PLANNING CONSULTATION RESPONSE

Application No	2026/0426
Proposal	Conversion of stable block to 1no. dwelling
Address	Land west of Cliff Lane, Brierley, Barnsley S72 9HR
Date of Consultation Reply	25 th June 2026
Consultee	Highways DC

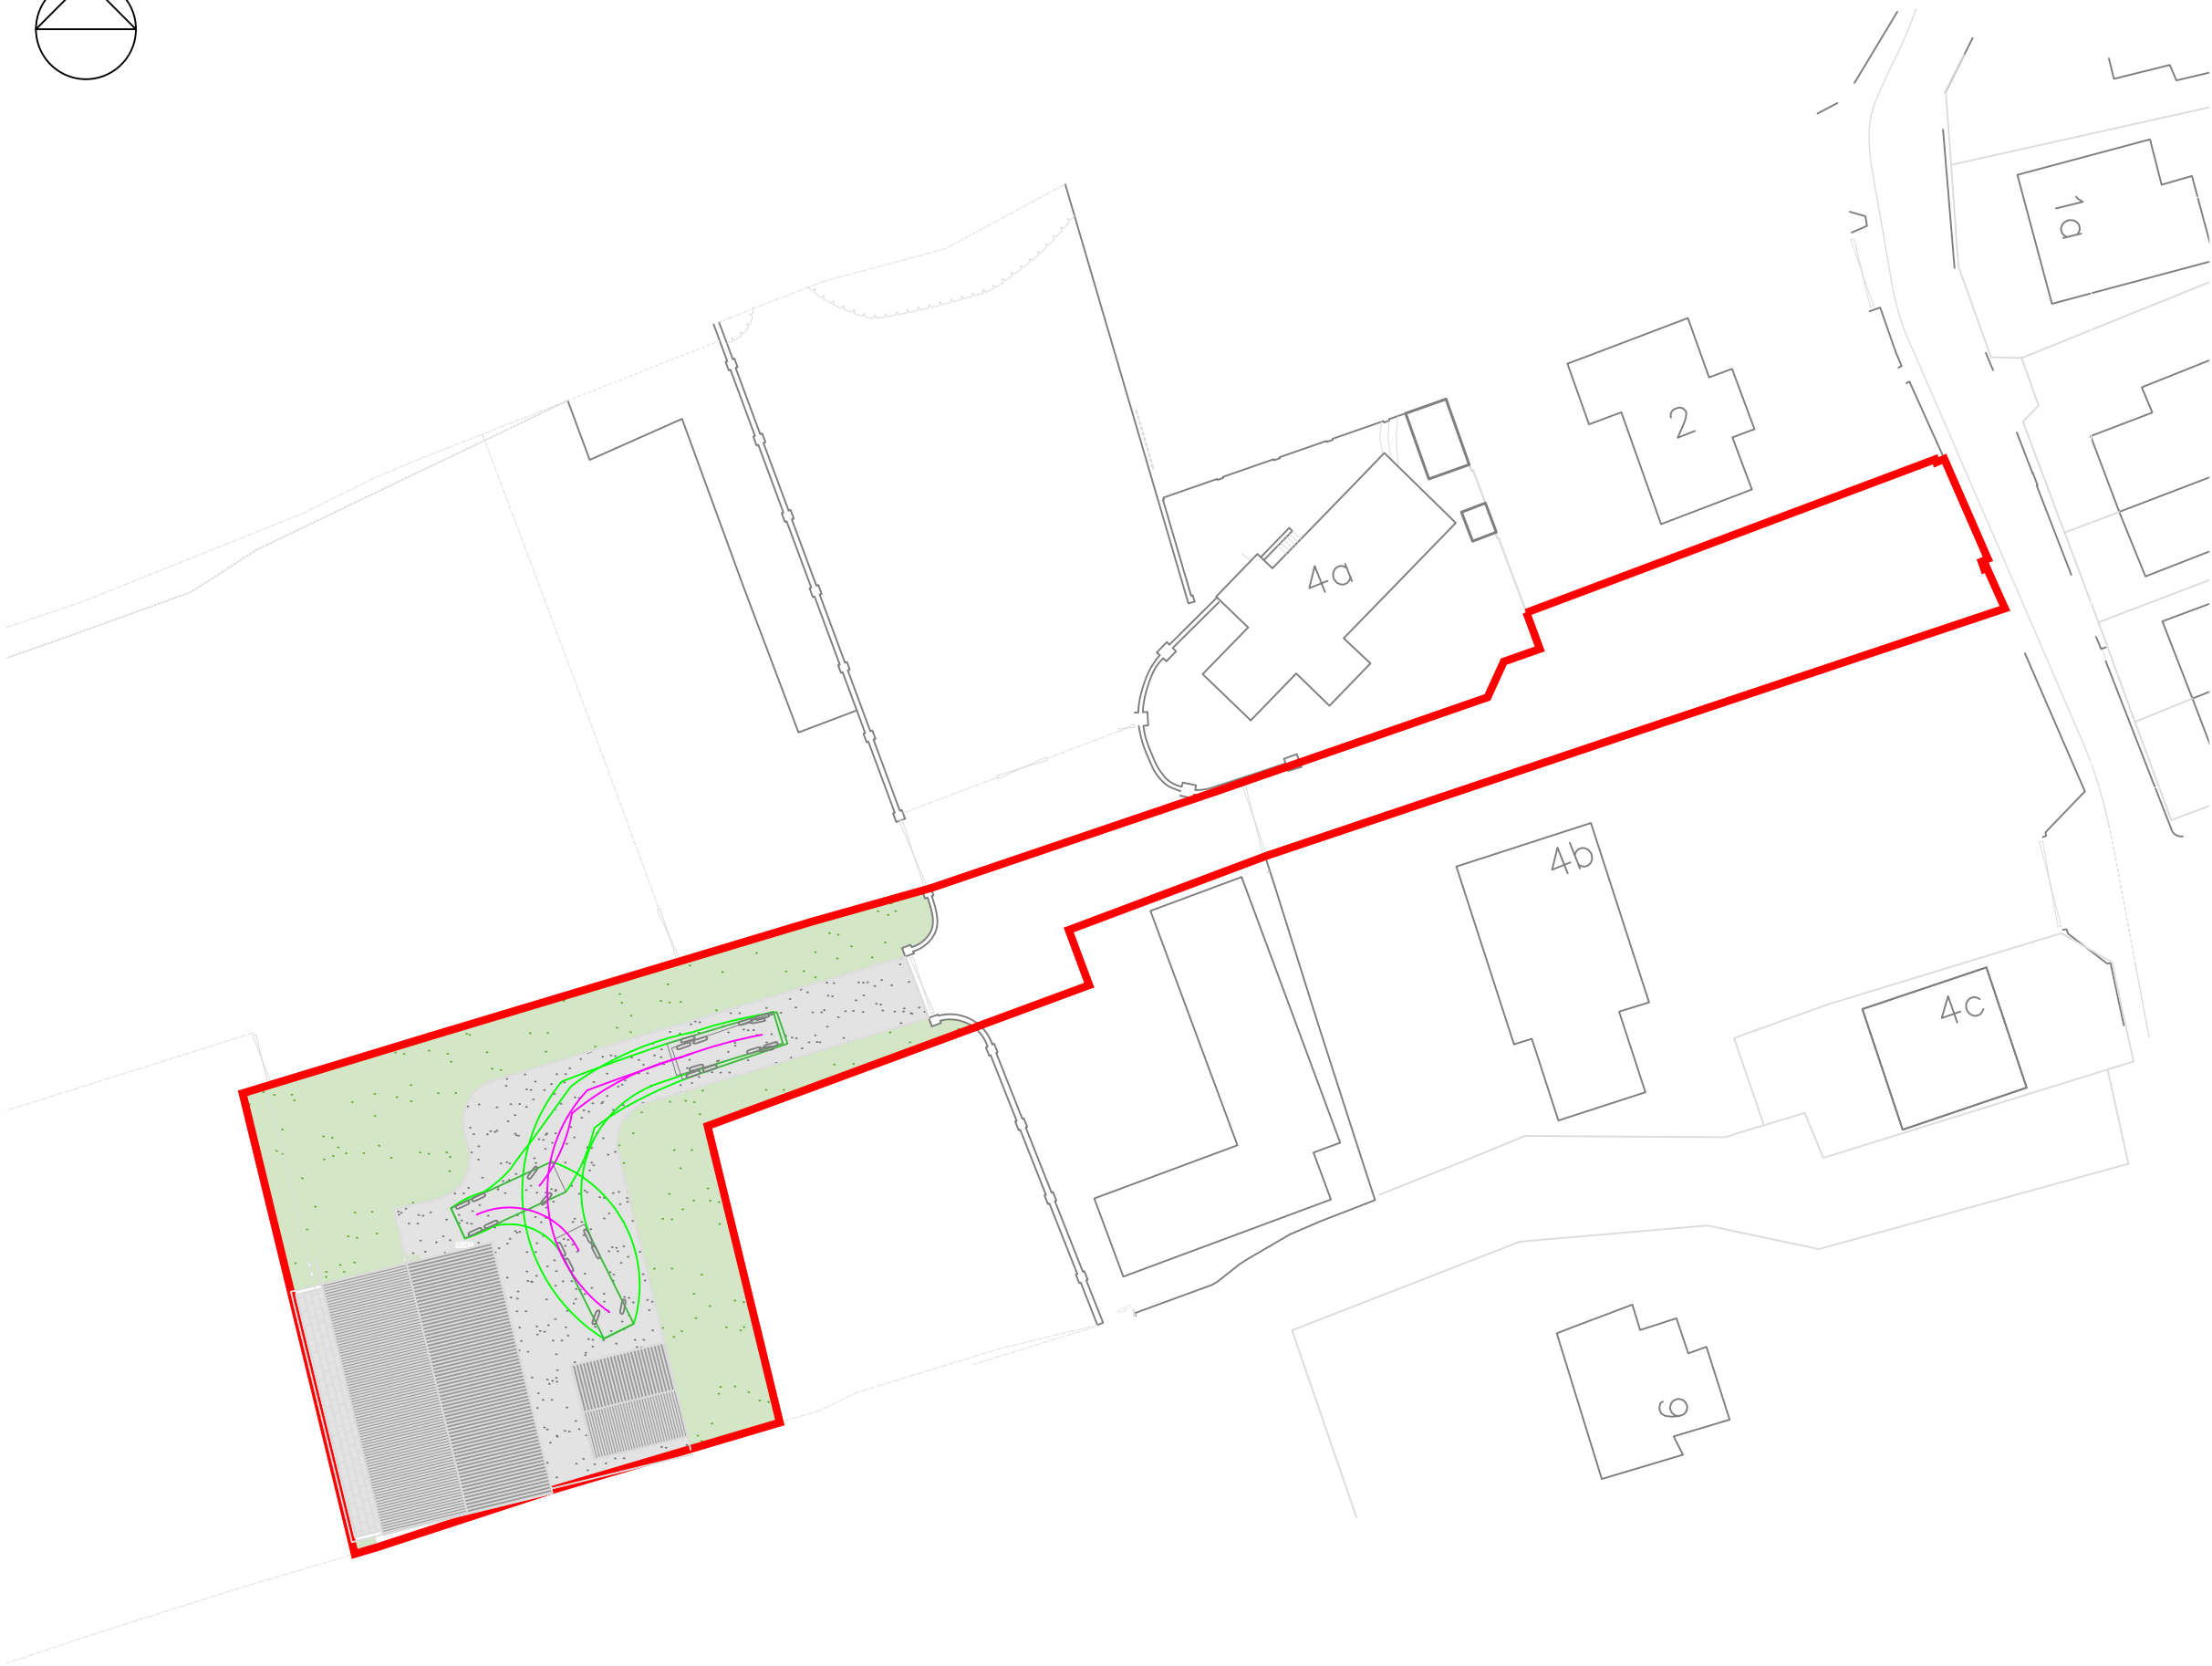
Notwithstanding the above, the proposed use of the site for residential purposes requires that vehicular areas are to be properly surfaced and drained, that there is suitable turning provision for a fire appliance and that there is adequate provision for refuse collection. Paragraph 9 of the supporting Highways Statement refers to the provision of a refuse collection point and that the turning area will be suitable to accommodate the swept path manoeuvre of a fire appliance, however, these details are not shown or demonstrated on the site layout plan.
